Cambridgeshire County Council and Fenland District Council

Relevant Representations

- 1.1 On 15 November 2022, Cambridgeshire County Council (CCC) submitted their Relevant Representation to the Planning Inspectorate (PINS) jointly with Fenland District Council (FDC) in respect of the application for a Development Consent Order (DCO) submitted by Medworth CHP Limited for a Combined Heat and Power (Energy from Waste) Facility.

**Figure 10.1i**  
**New Bridge Lane access design**

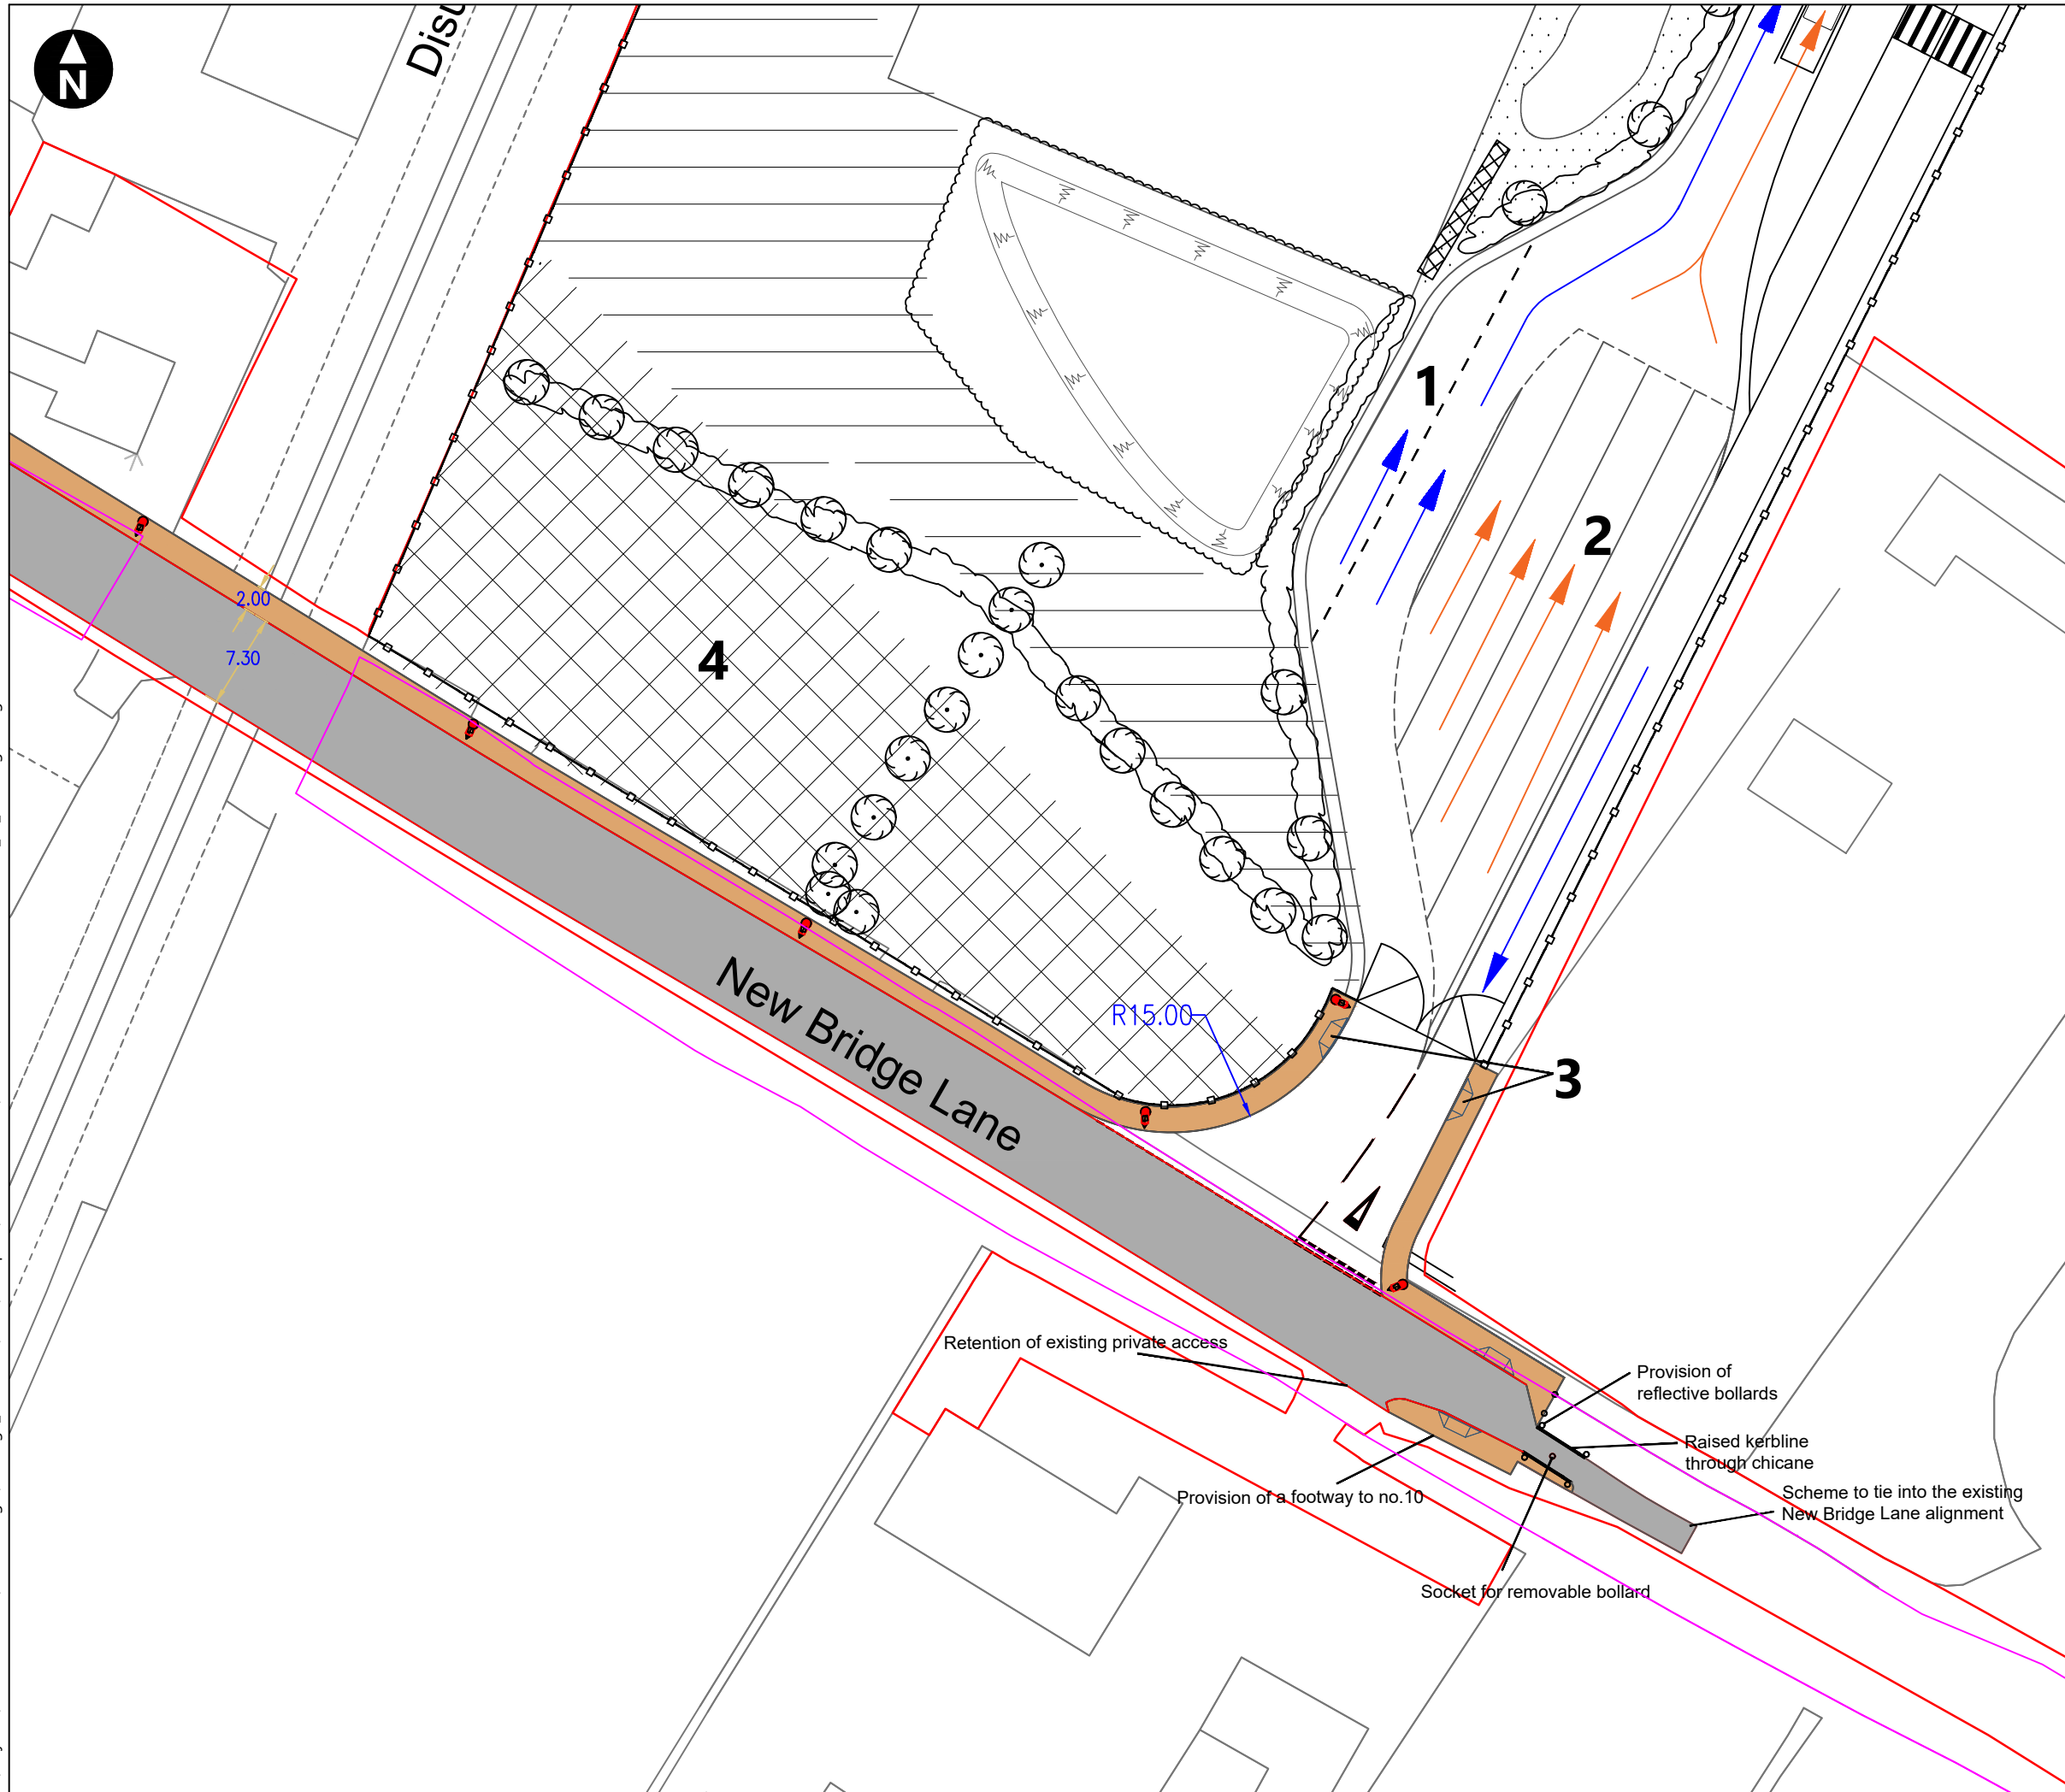
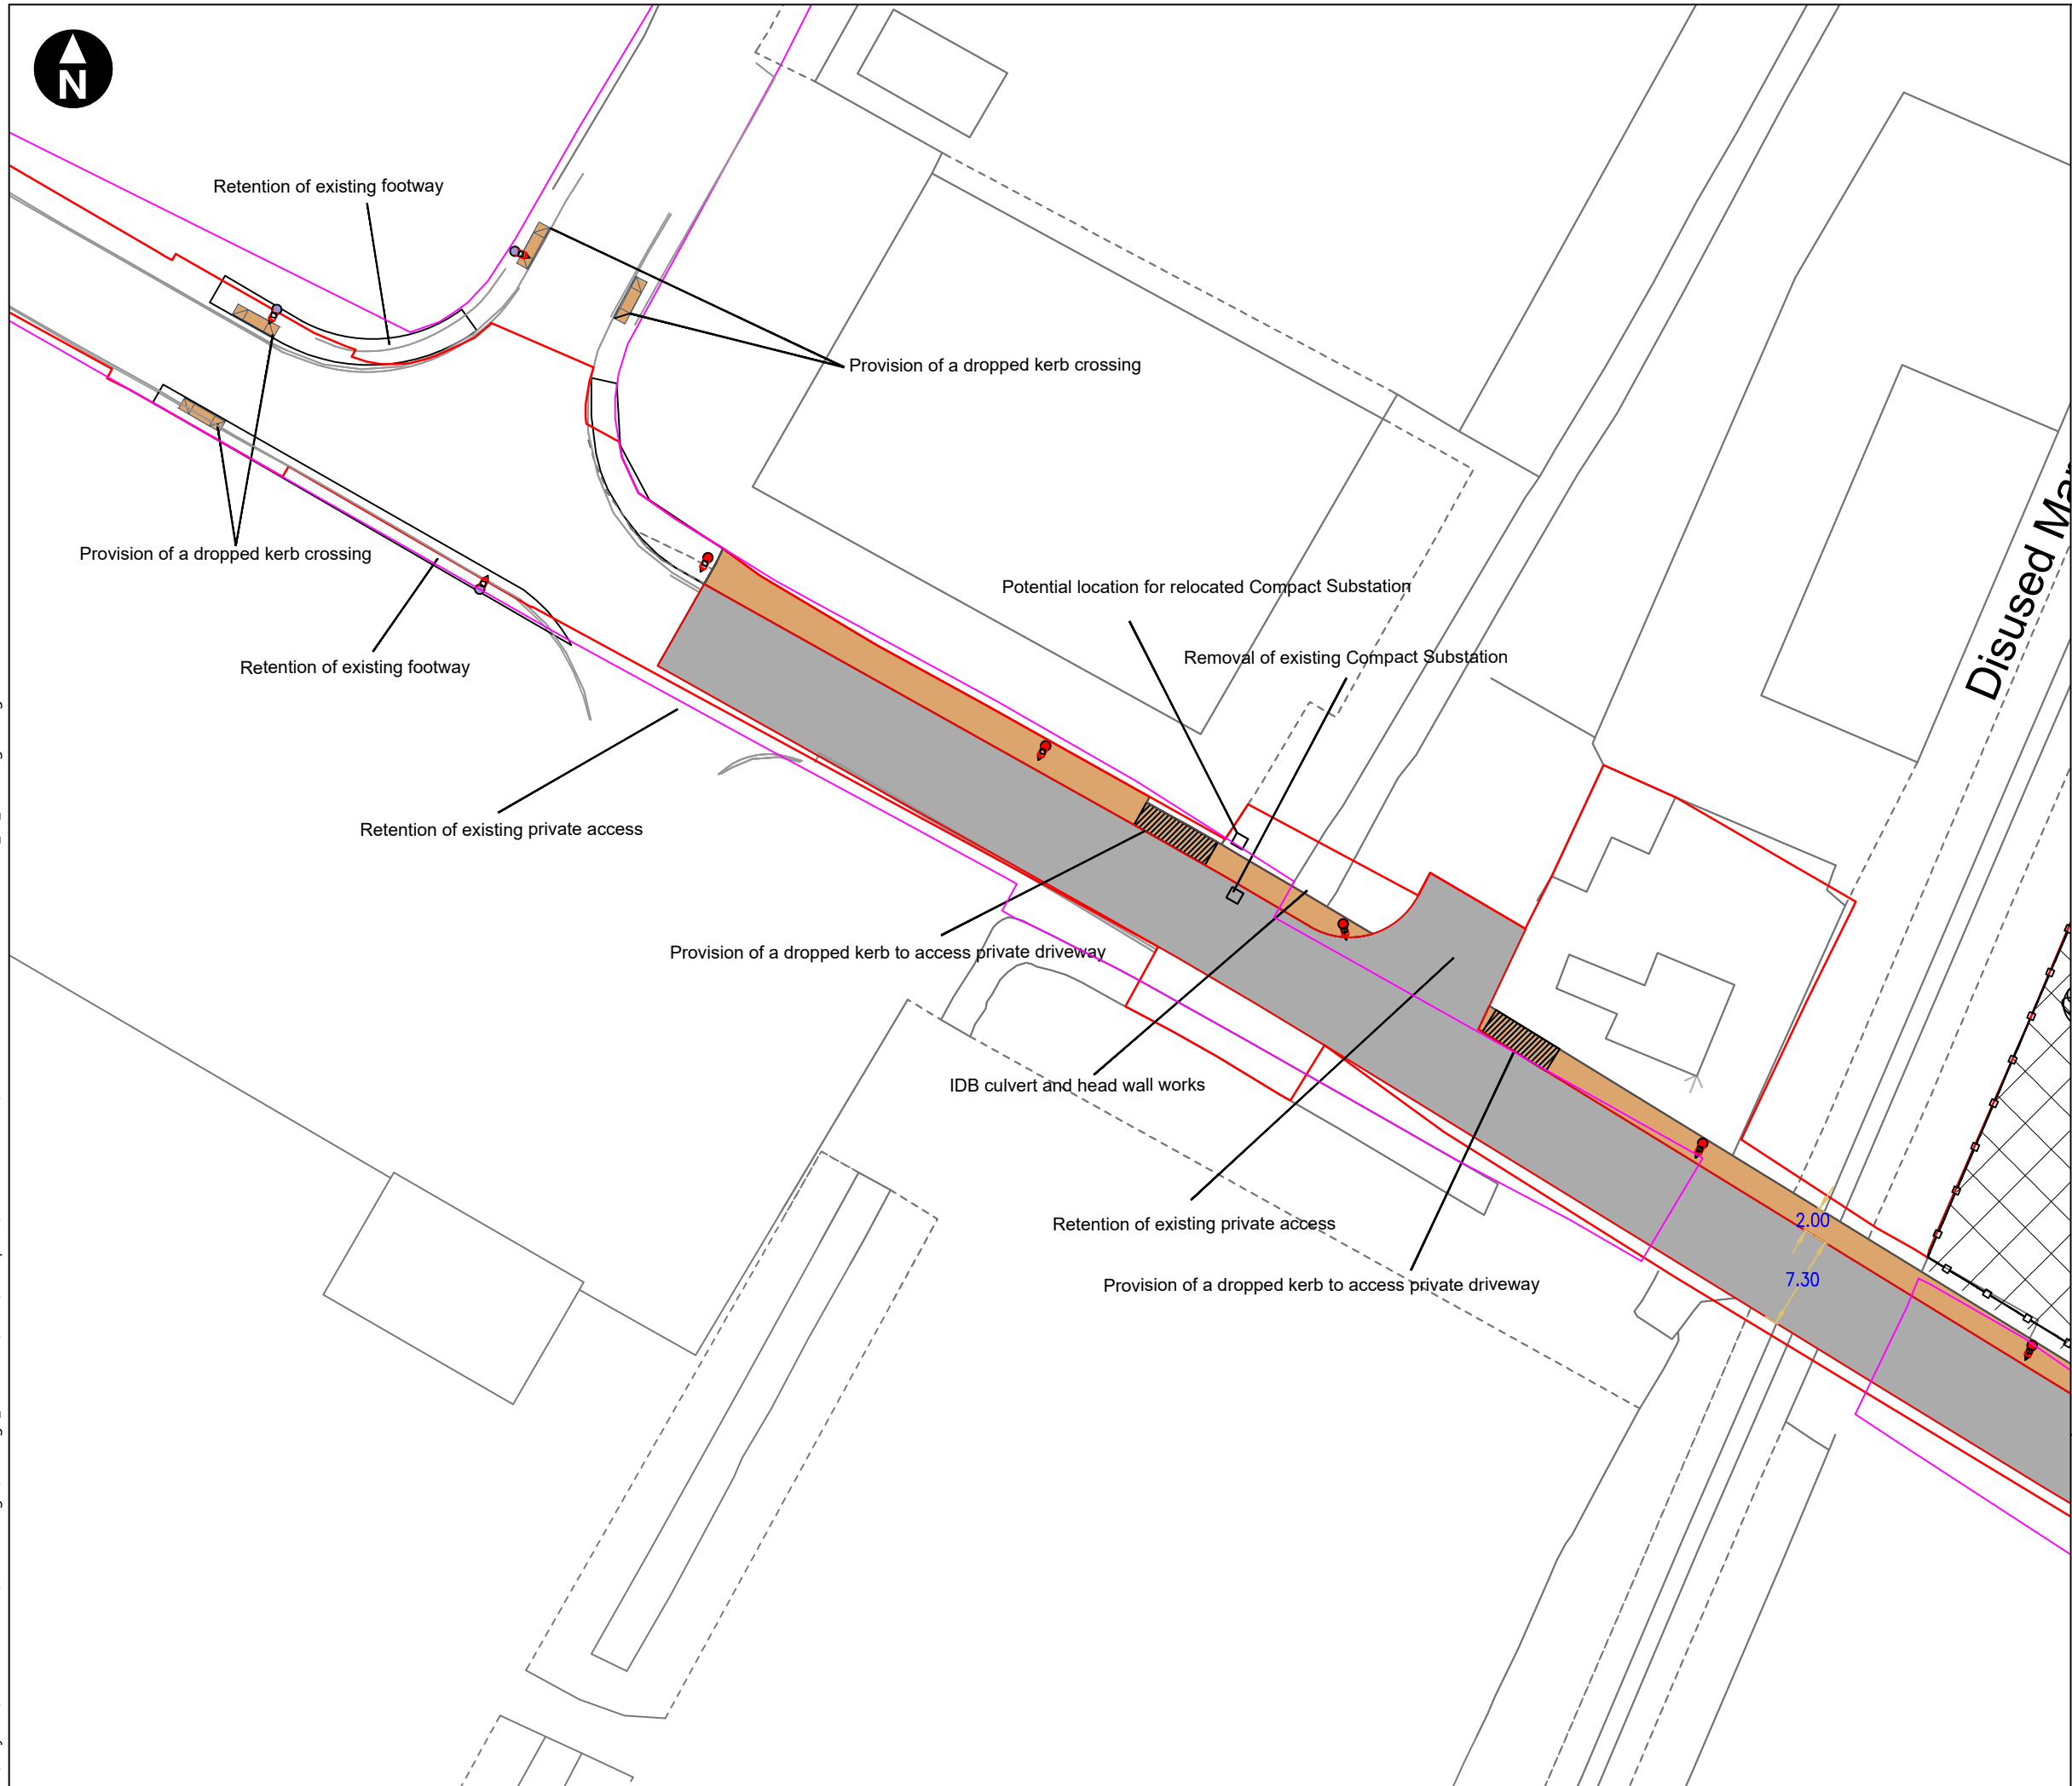
- 3.7 New accesses A3, A4 and A5 are to be maintained at public expense. This is unacceptable to CCC as these accesses are not connected to any publicly maintainable highways.
